Planning Officer: Mr F Gardner
Planning Application Ref: EP/43/20/T
Location: Preston Hall, Timberley, The Street, East Preston, BN16 1HU
Description of works: Fell 1no. lime tree
Reasons Given: Root damage to property (garage entrance and concrete driveway)
Comments on Application:

TREE
WANT
REMOVING

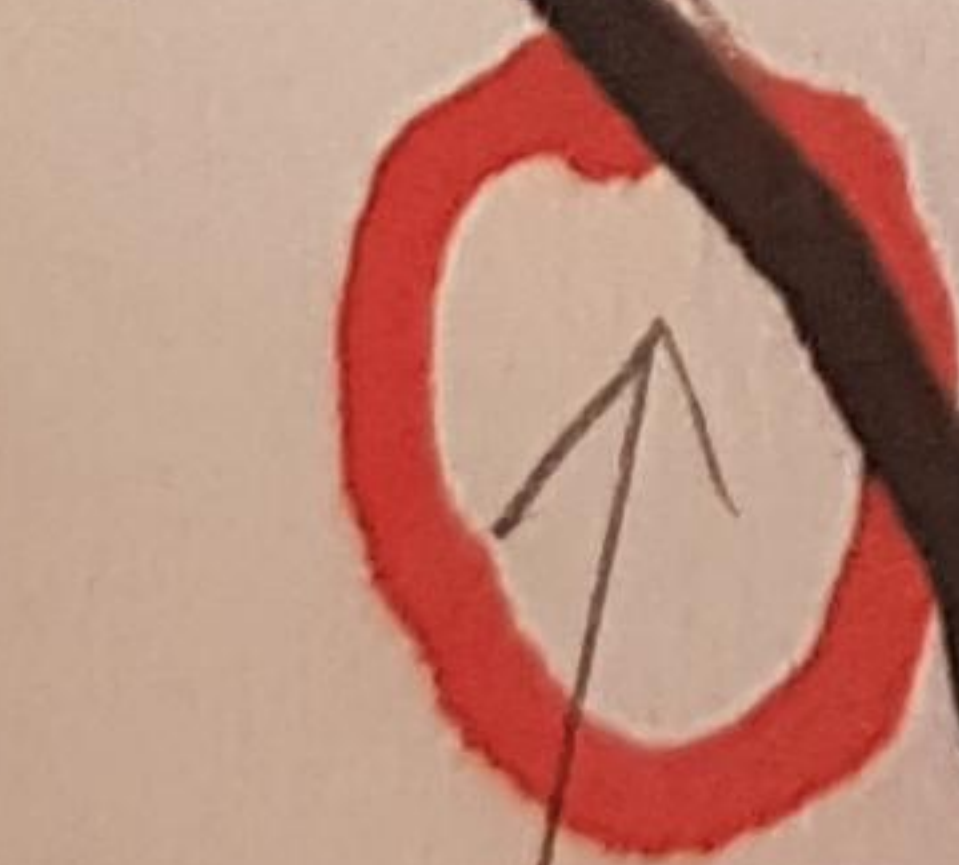
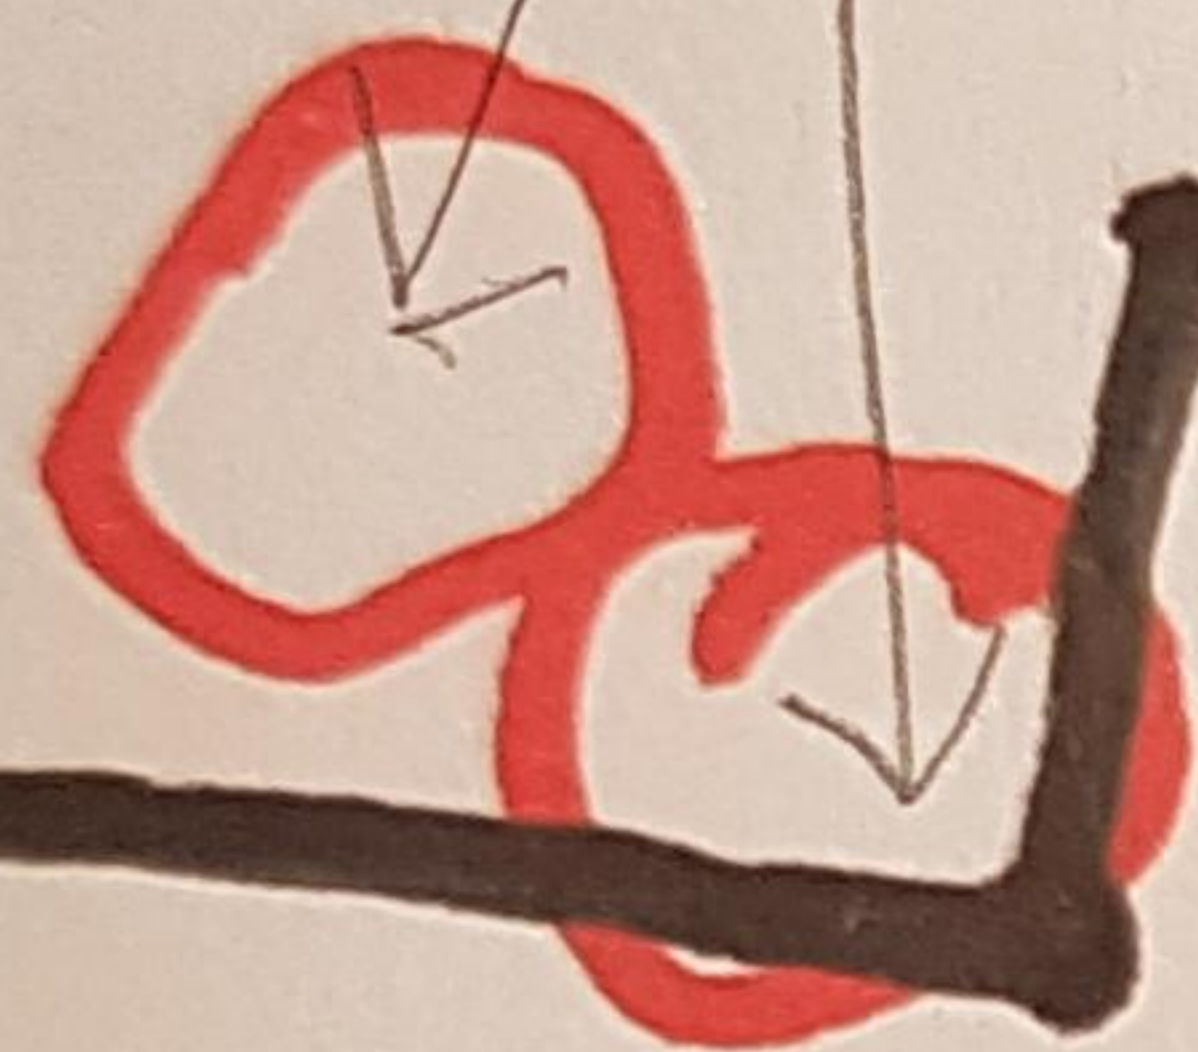
- It seems likely based on ground conditions, structures and anecdotal evidence described in the above report – substantial interference with soil structure/tree roots will have occurred. Although outwardly this tree appears to be in a fine physiological state, conflict and damage between it and built structures introduced within influencing-distance was inevitable - we have now arrived at situation which could reasonably be deemed intolerable for the occupier(s).

- The work proposed is justified on arboricultural grounds as the ongoing presence of T1 is not compatible with the continued use of garage extension and driveway restoration of any type.
- This is an unfortunate but necessary course of action. Although foreseeable, we must acknowledge the damage arising from the ongoing presence of the tree and sanction its removal – which can be mitigated with the planting of a suitable replacement tree in a more harmonious position on the plot.

Once the tree (T1) has been felled (and either grubbed or ground out) then a replacement tree is to be planted outside the crown spread of nearby trees to aid establishment and to within 15metres.
